WEST SUSSEX COUNTY COUNCIL CONSULTATION

TO:	Arun District Council FAO: Zac Denton
FROM:	WSCC - Highways Authority
DATE:	29 April 2019
LOCATION:	Land at Entrance to Waterford Gardens Climping Littlehampton BN17 5PQ
SUBJECT:	CM/18/19/PL Erection of 2 No 3 bed dwellings with off-road parking and associated landscaping.
DATE OF SITE VISIT:	
RECOMMENDATION:	More Information
S106 CONTRIBUTION TOTAL:

drawing title:
Site Plan

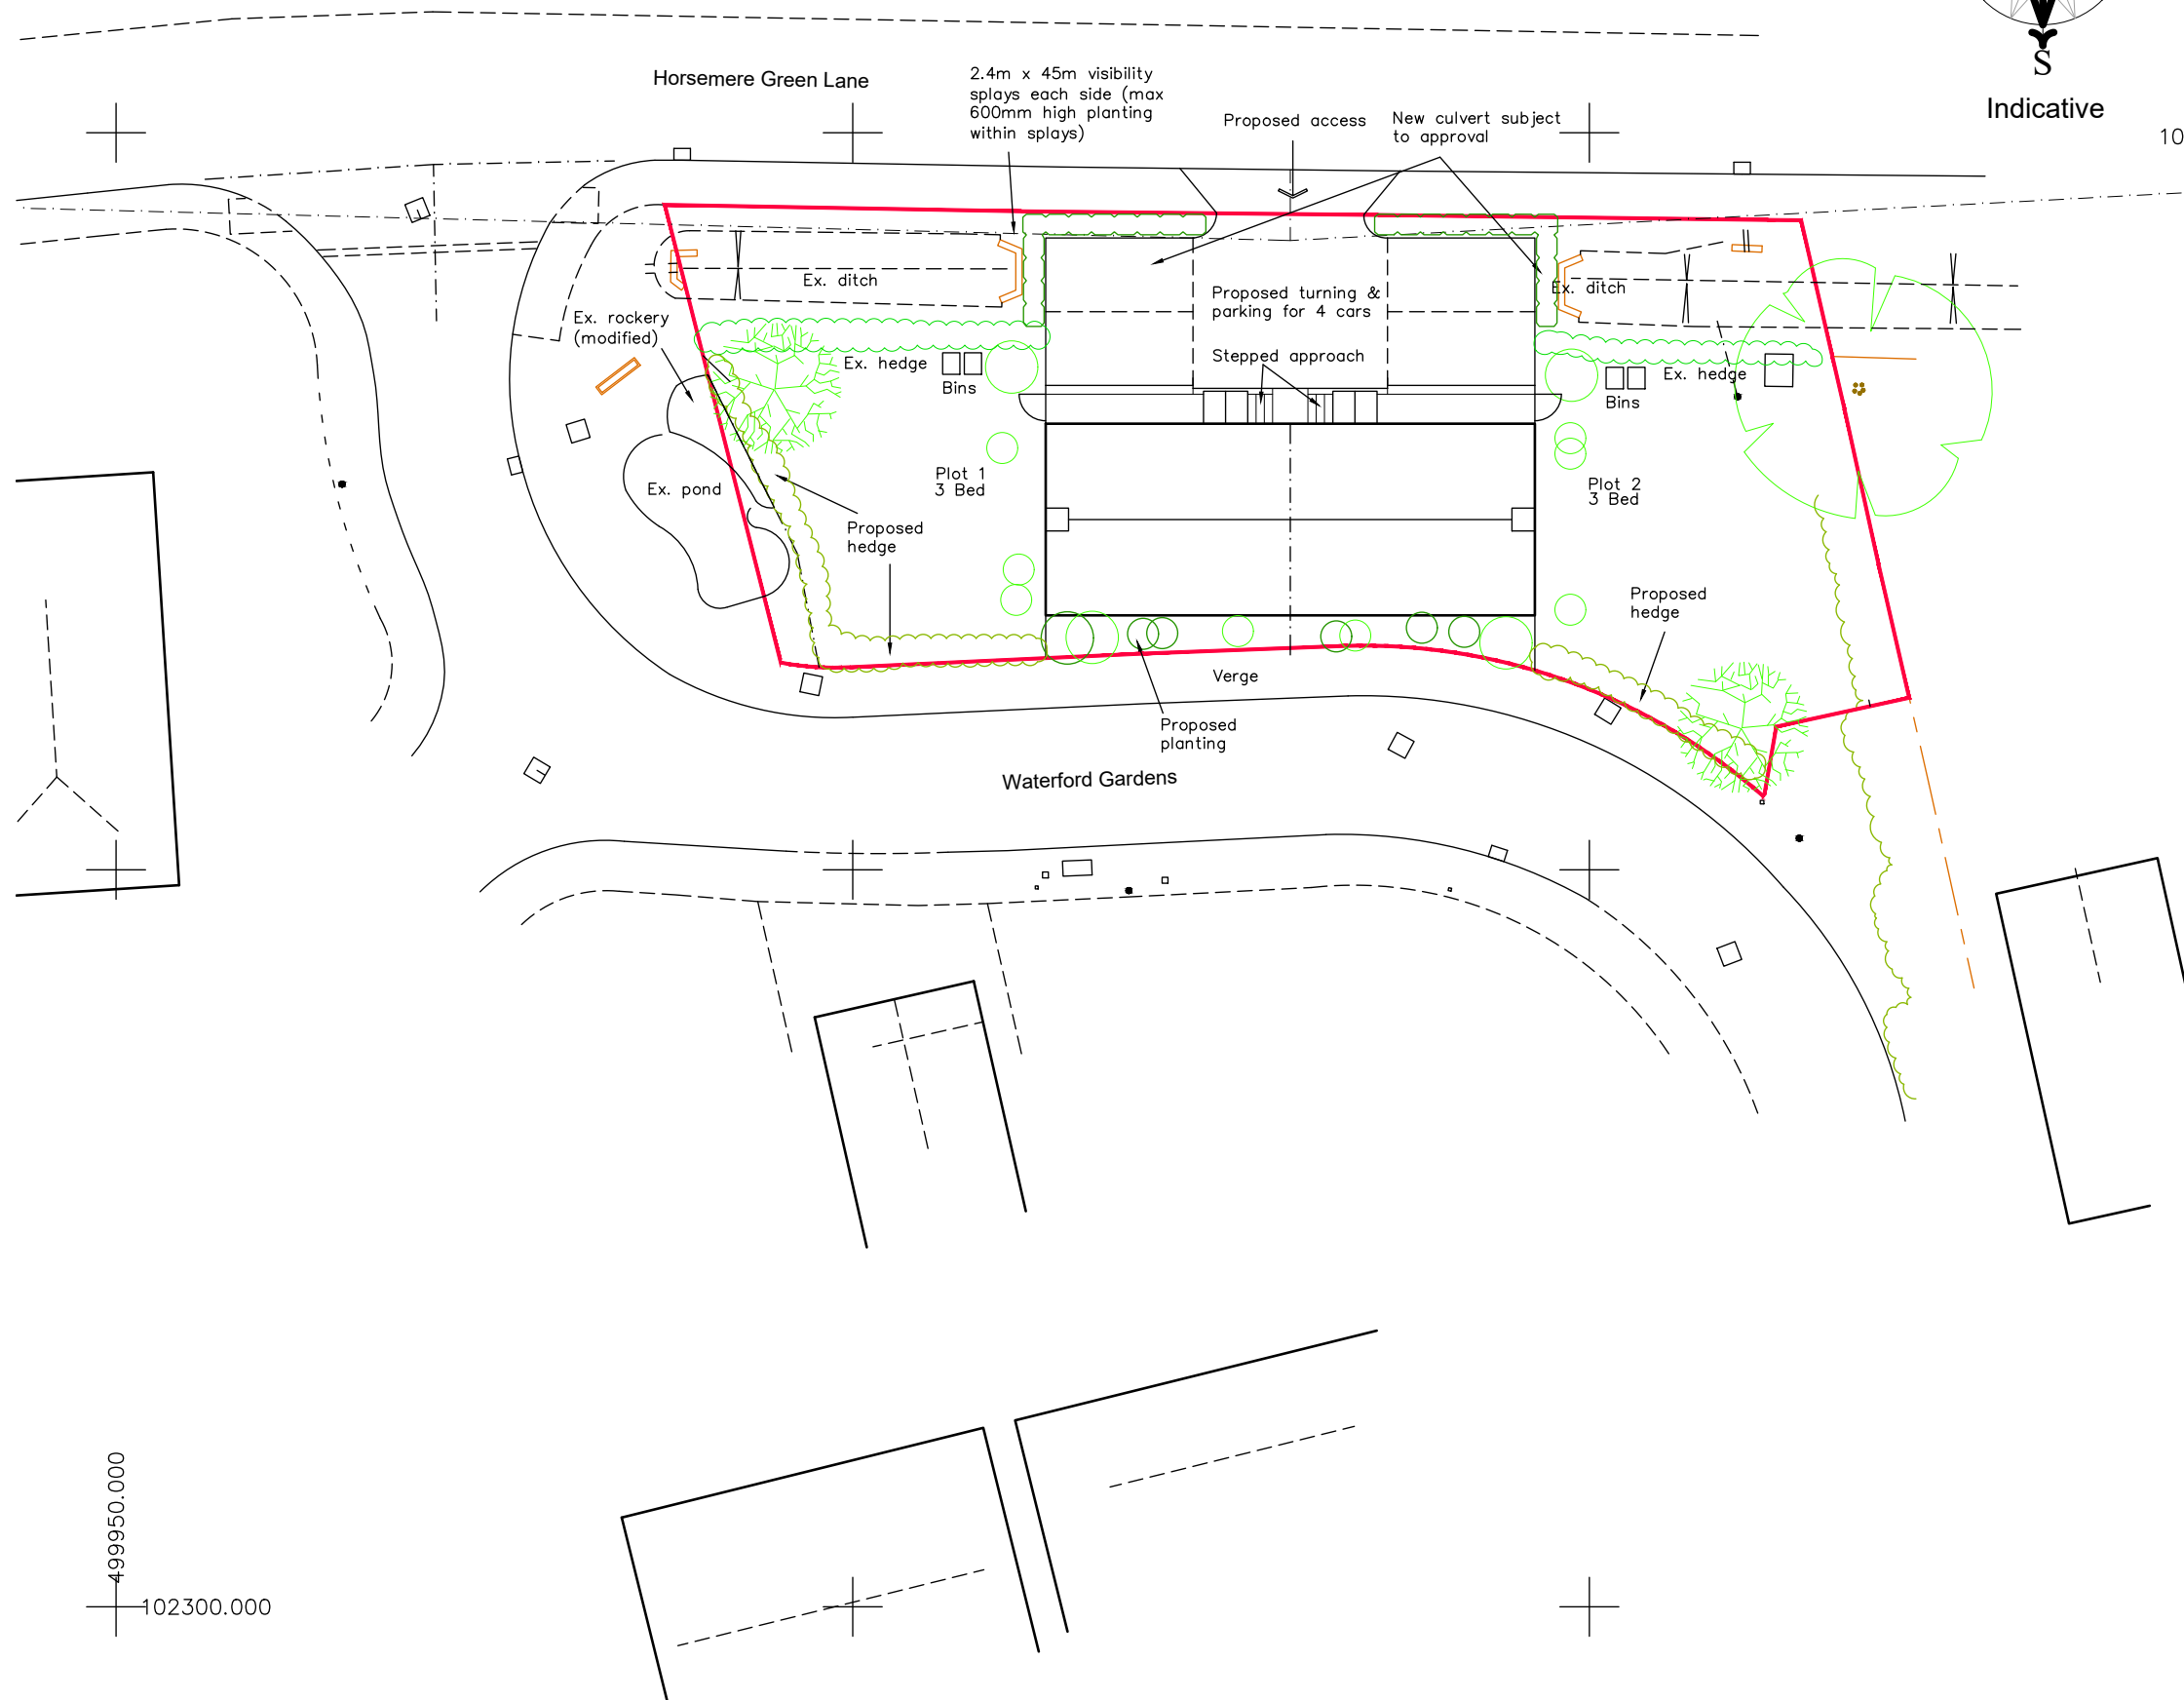
- Lockable covered cycle parking to be provided on plans,
- Plan Showing full extent of Vehicle Visibility Splays, I have attached a diagram showing how they maybe drawn,

- Plan Showing full extent of pedestrian Visibility splays, I have attached a diagram showing how they maybe drawn.

- It should be noted that there should be no obstructions of any kind in the Highway, as the submitted plans show shrubbery within this zone.
